From: Carmichael Ian [mailto:Ian.Carmichael@thamesvalley.pnn.police.uk]
Sent: 02 August 2019 09:50
To: Bob Neville
Cc: Planning
Subject: Planning ref: 19/01177/F. Land to the South of and Adjacent to South Side Steeple Aston.

Planning ref: 19/01177/F. Land to the South of and Adjacent to South Side Steeple Aston.

### **SITE LAYOUT**

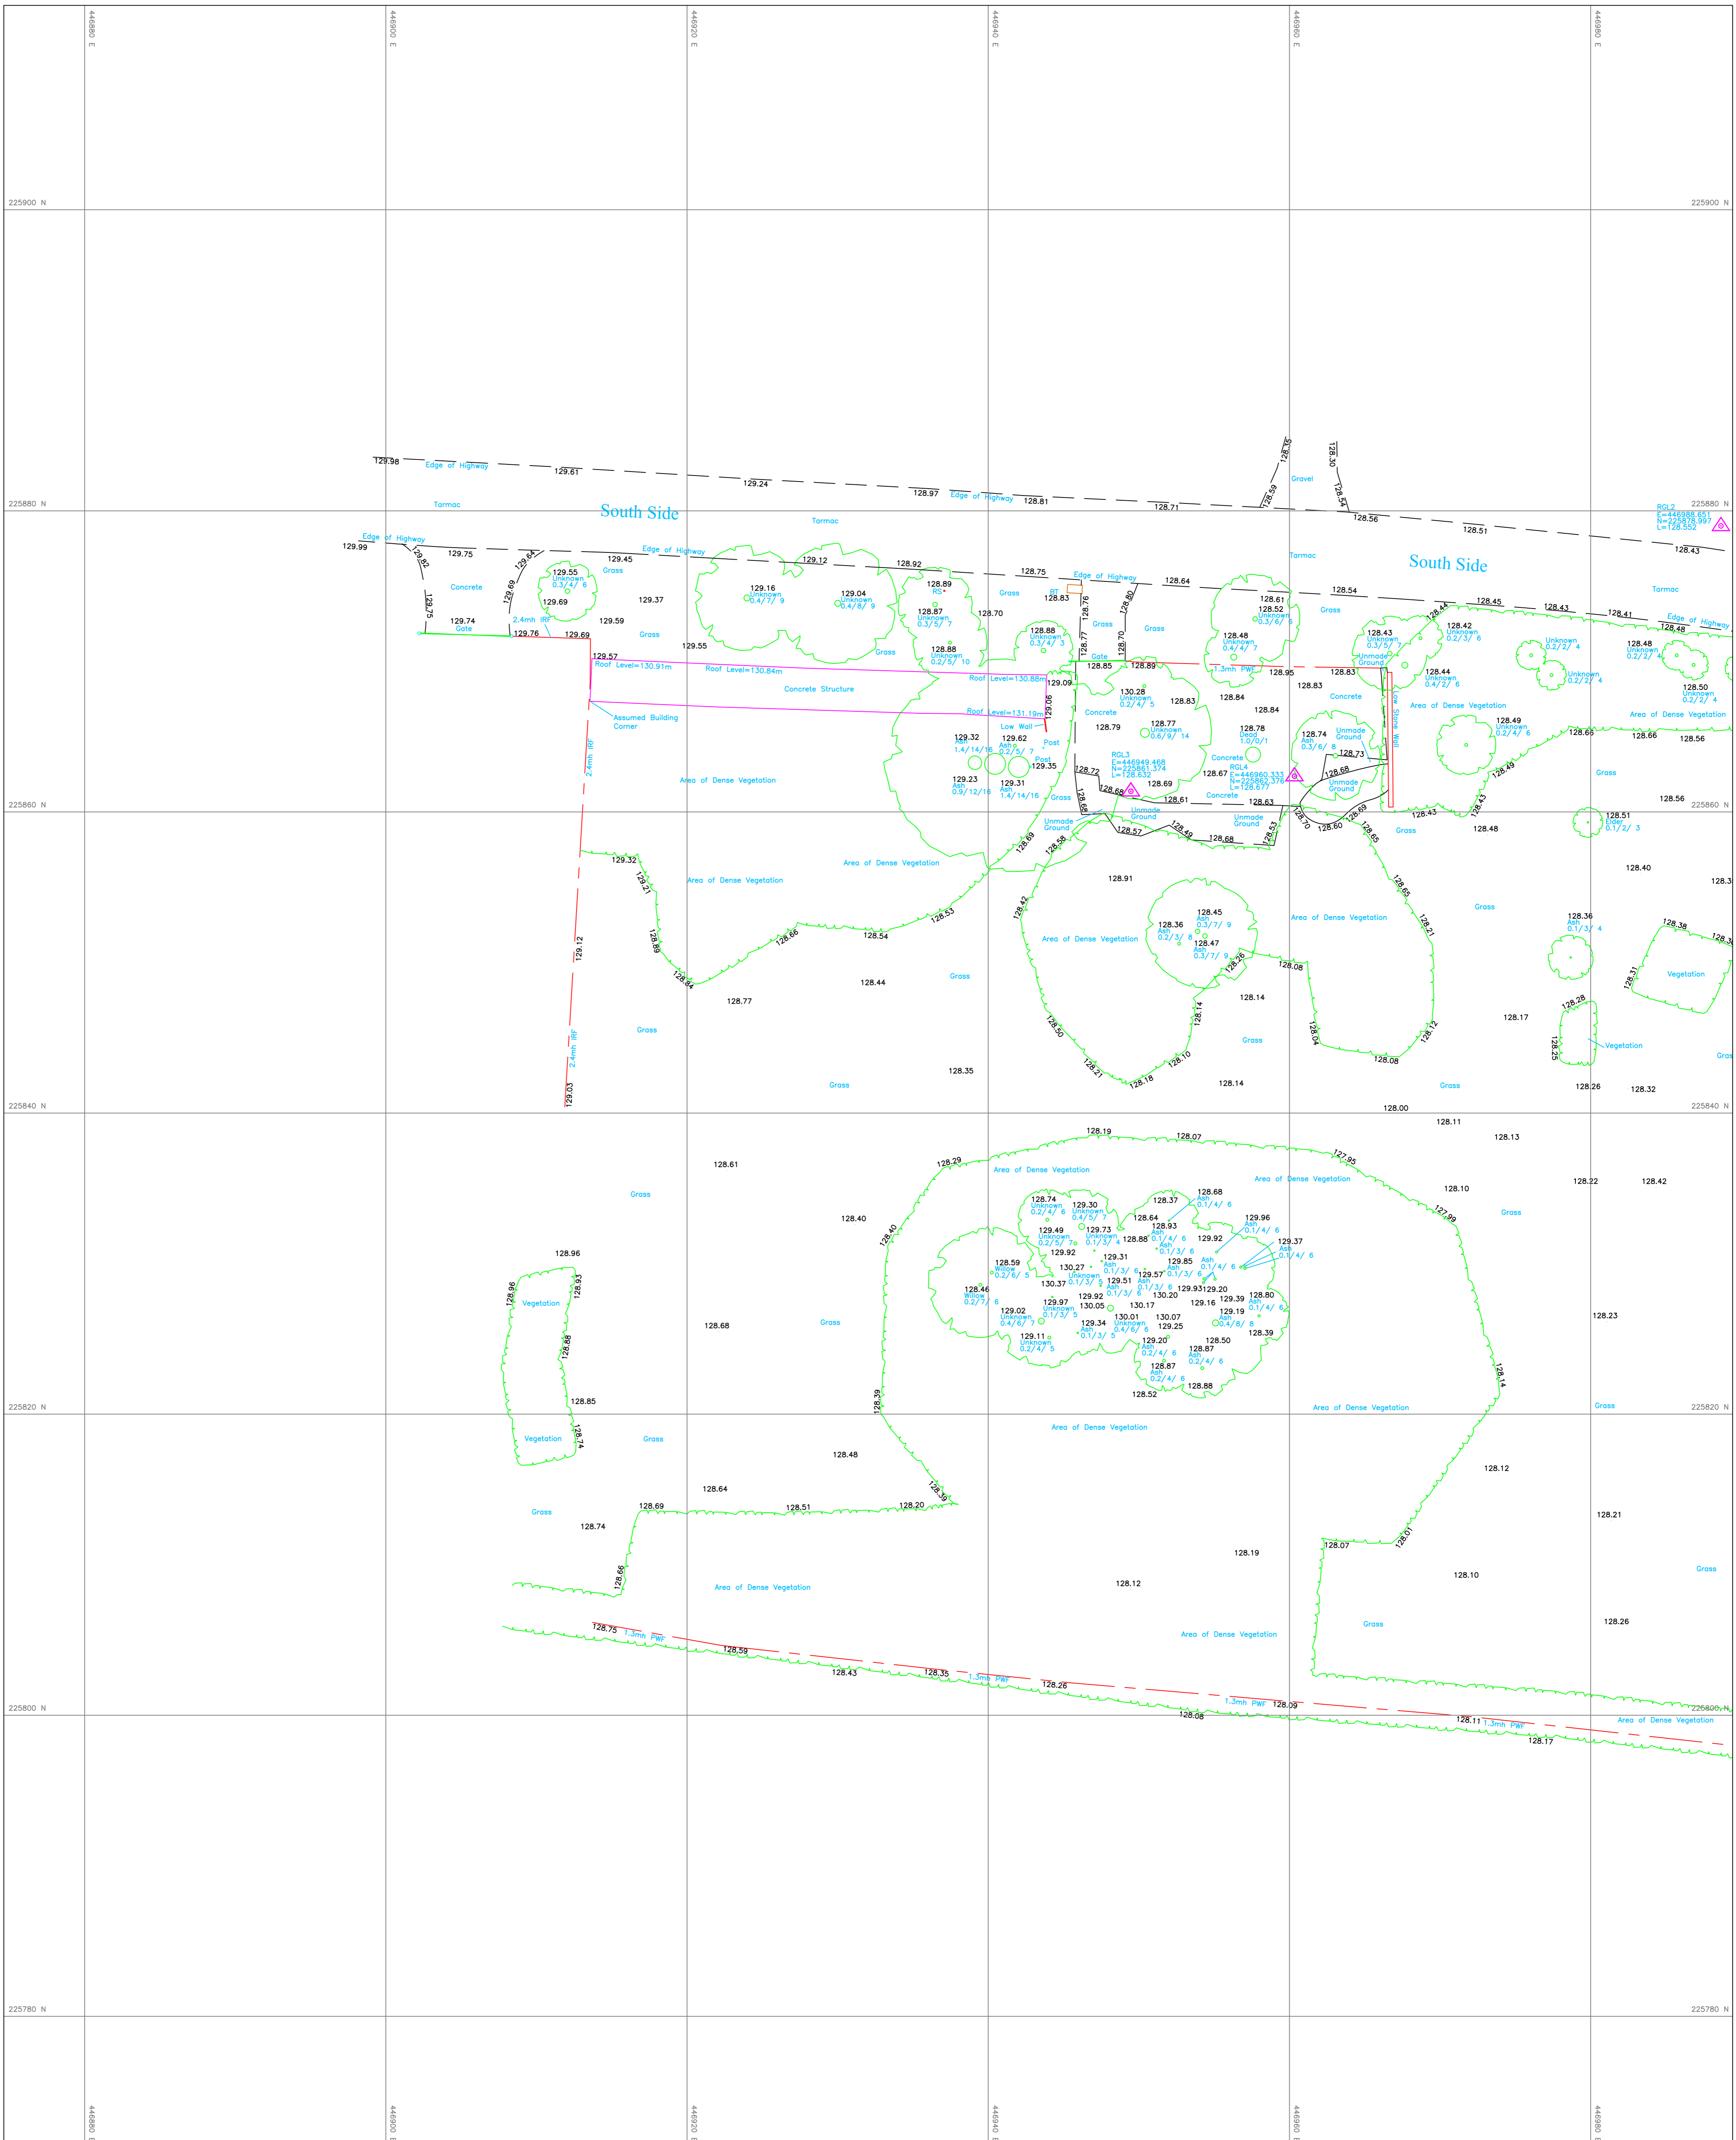
- All access gates to rear gardens should be; robust, of the same height as boundary treatments, self-closing, have anti-lift hinges and be key operated from both sides. I note that some are not positioned as close to the front building line as possible. This creates problematic recesses and should be rectified wherever possible.

- Hedges within front gardens and the one that runs along the side of the pedestrian footway at the east end of site should have a final growing height of no more than 1m so that natural surveillance is not compromised.

- There should be a gap in vegetation of at least 2m either side of the pedestrian path at the point where it enters the site to allow for clear views along it from South Side.
